Document MCO 1.6

Updates to Application Documentation

The East Midlands Gateway Phase 2
and Highway Order 202X and The East Midlands Gateway
Rail Freight and Highway (Amendment) Order 202X

Section 51 advice for applicant relating to documentation as to submission dated August 2025

FPCR | environment & design

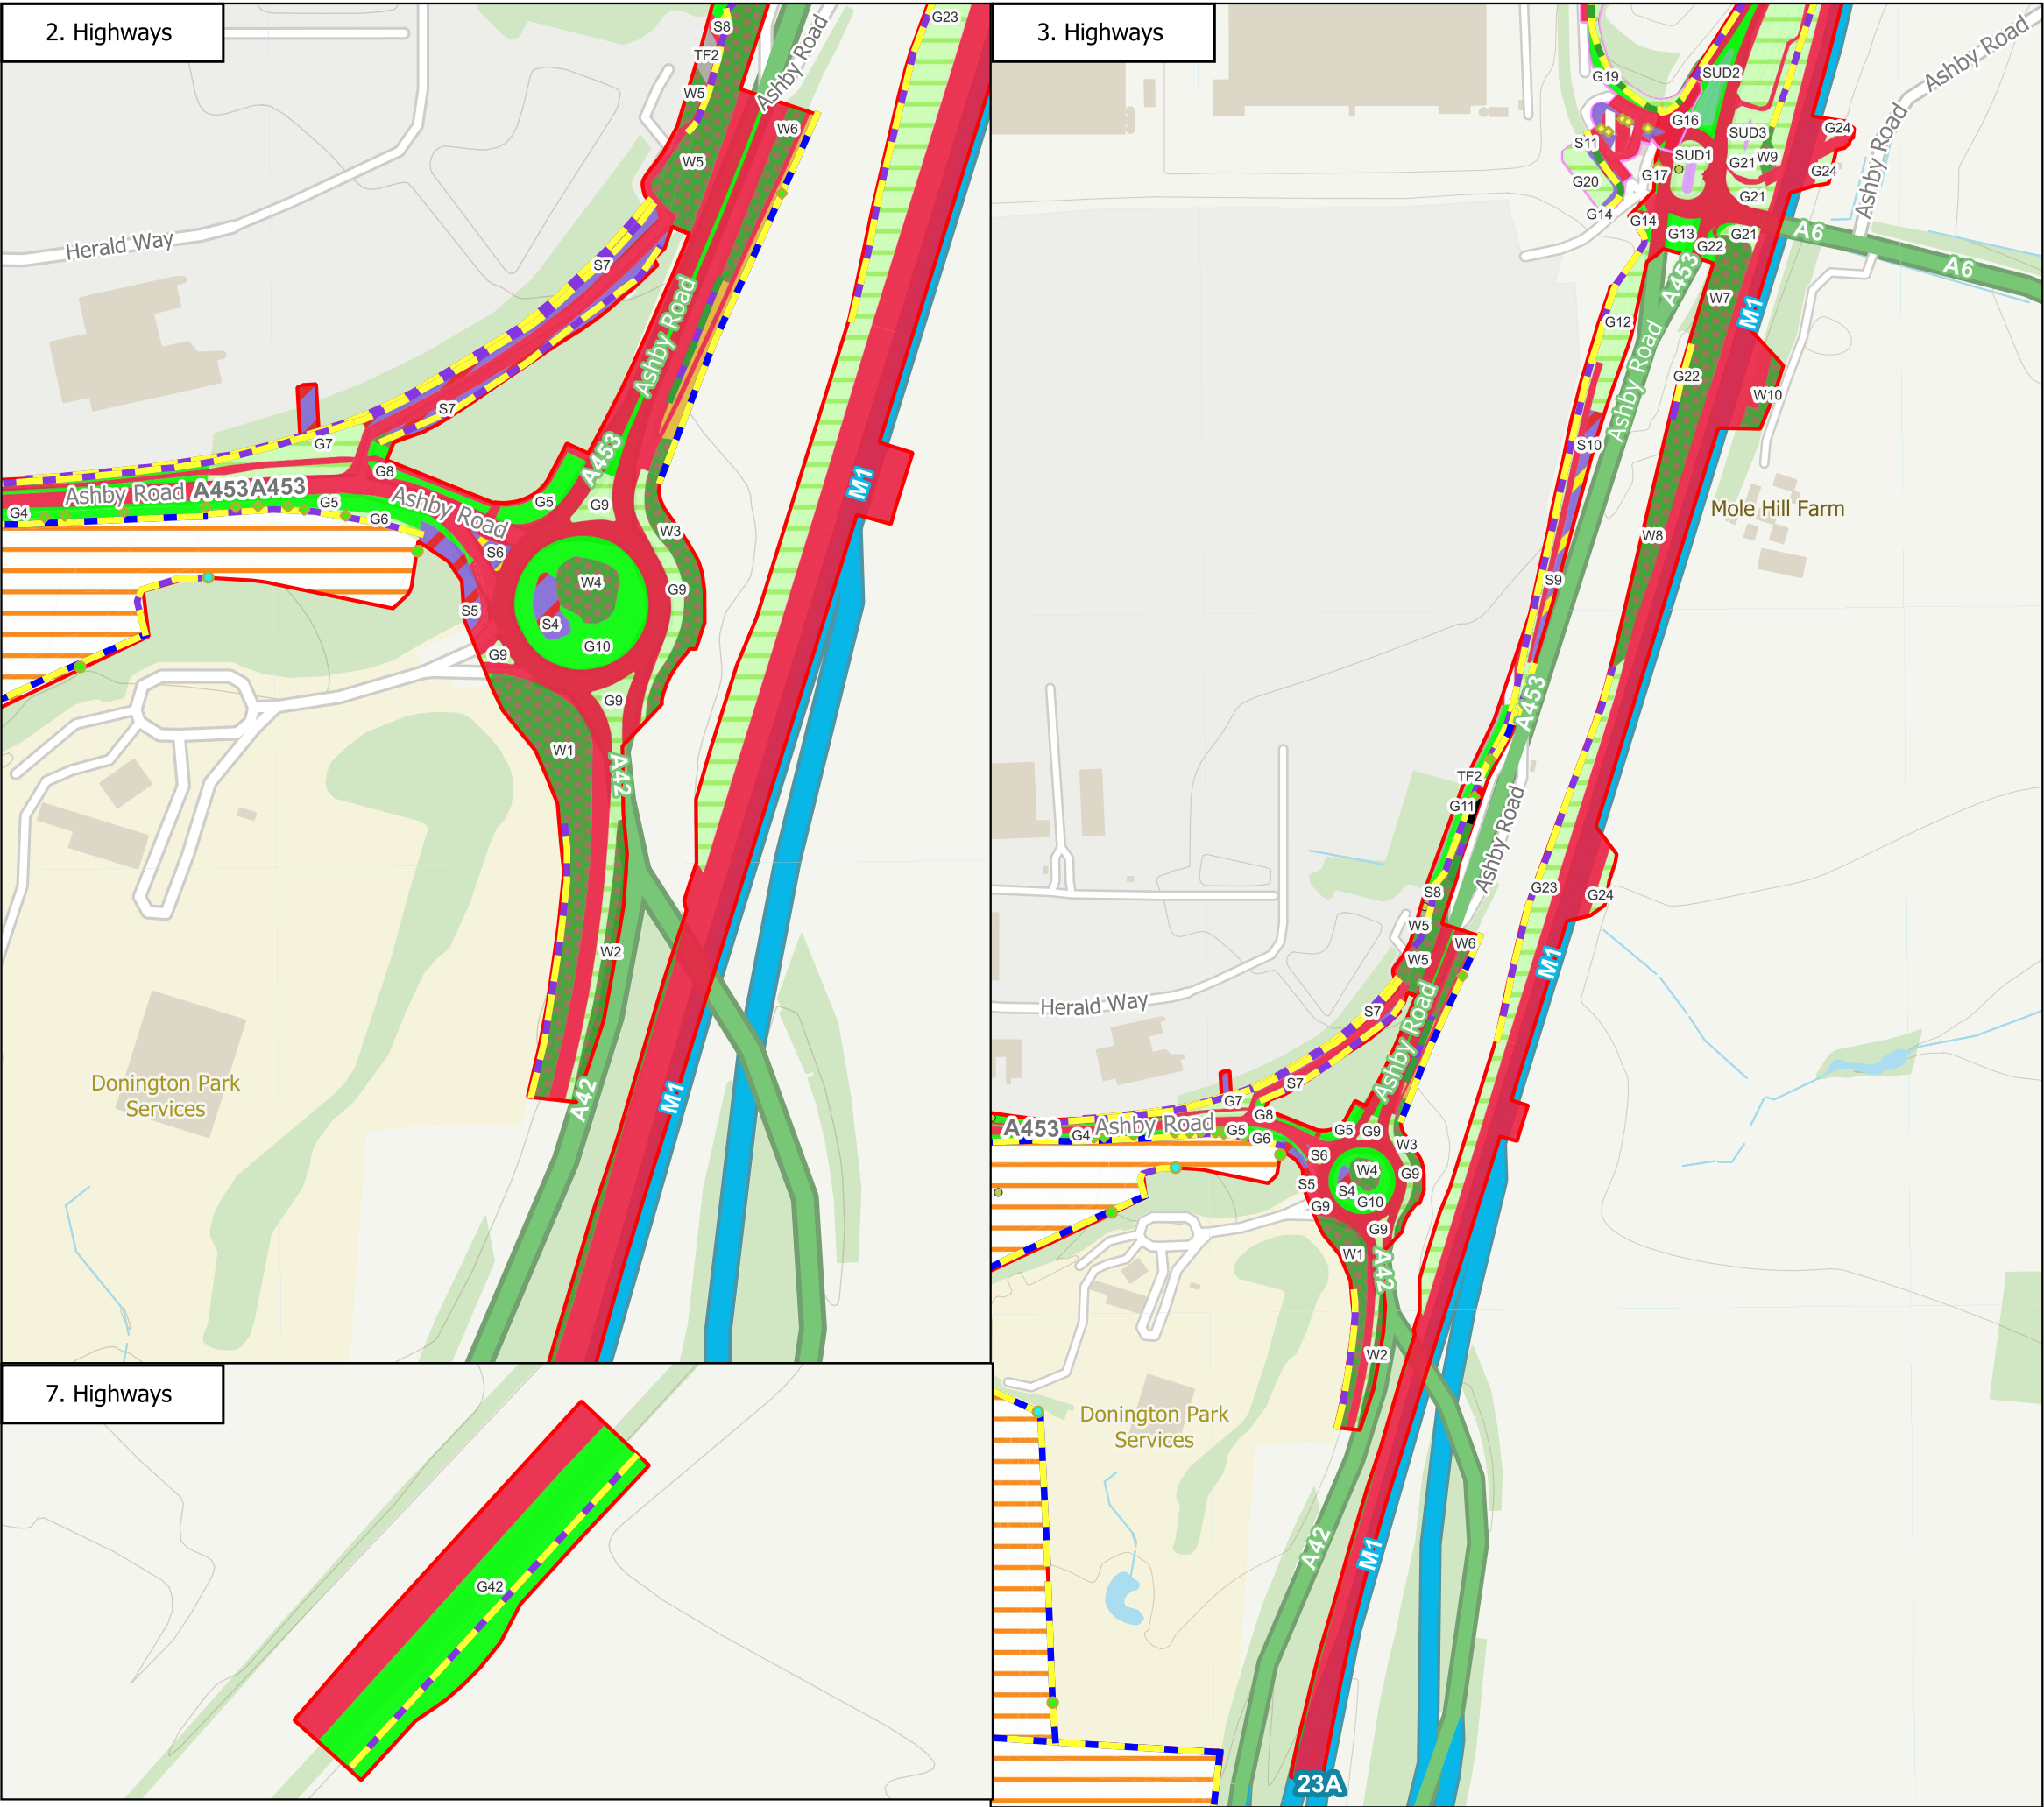
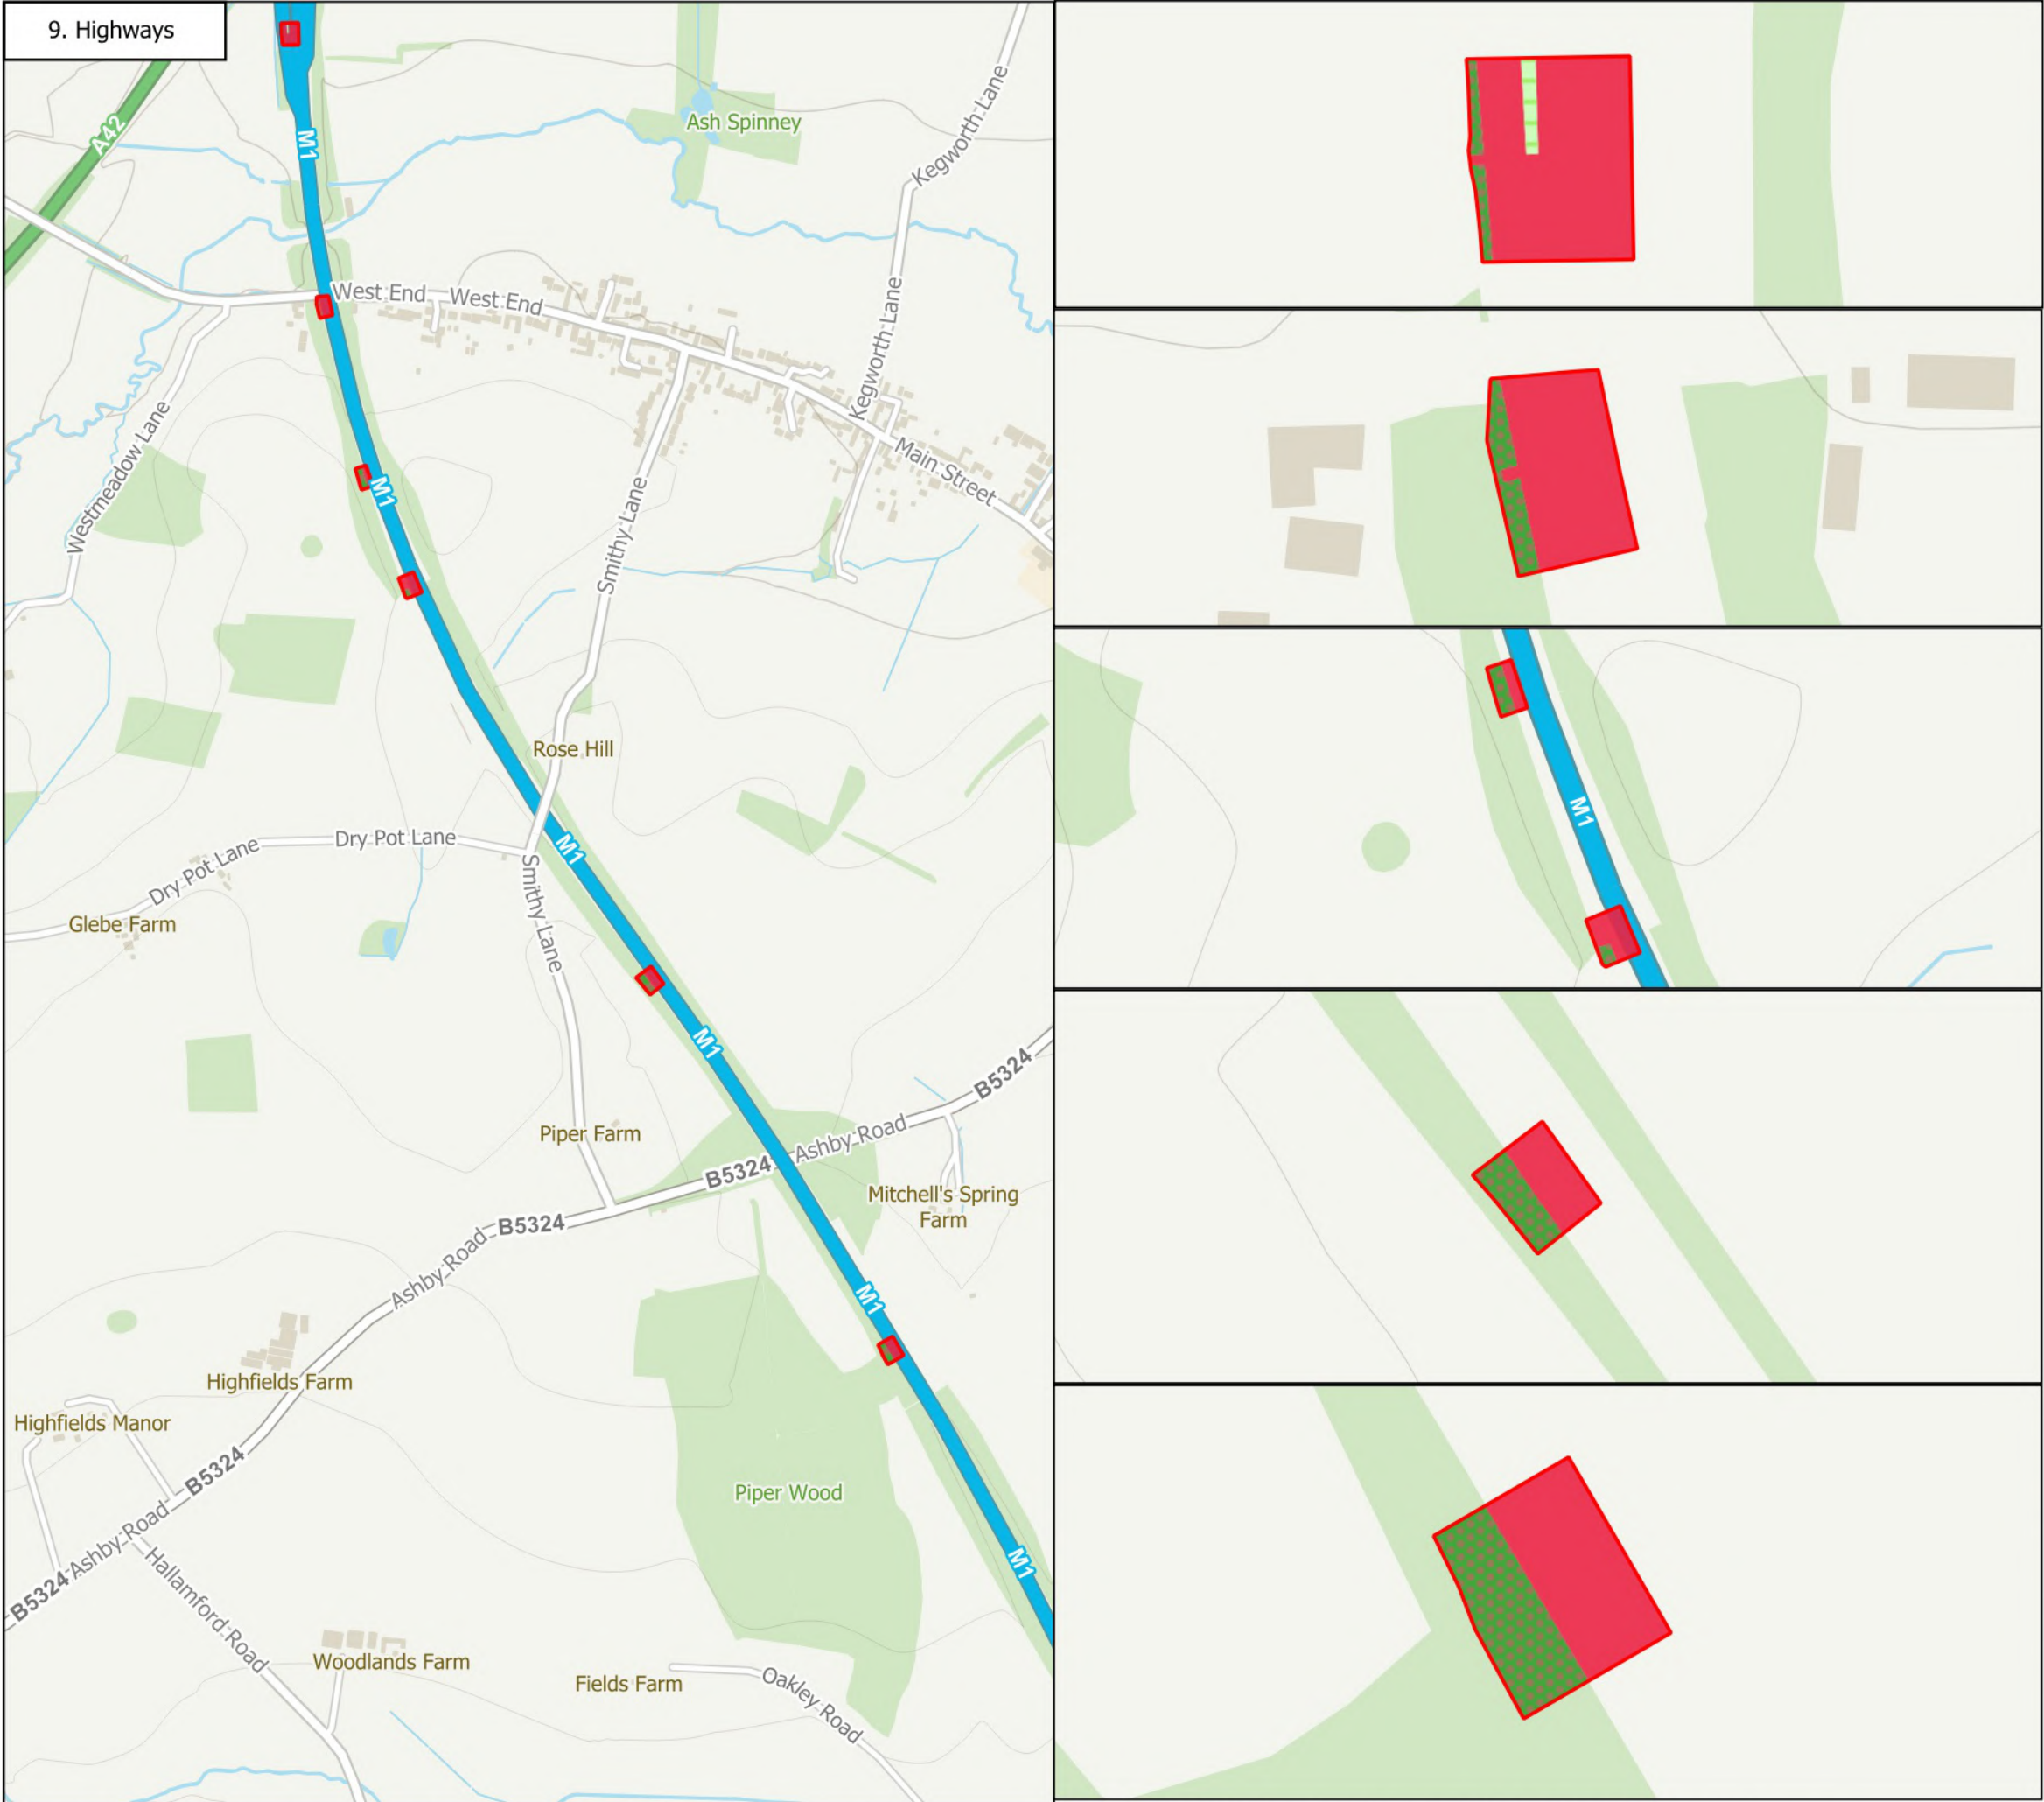
32.	<p>The following reports contain figures that are difficult to read (inappropriate scales, black and white/ indistinct mapping backgrounds):</p> <ul style="list-style-type: none"> • ES appendix 6.9A: Preliminary Ecological Appraisal • ES appendix 6.9D: Bird Report • ES appendix 6.9G: Reptile Report • ES appendix 6.8D: Modelled Ecological Receptor Locations 	Figures and maps used within the ES, particularly where these are embedded within text, should be reviewed for clarity and ease of understanding.
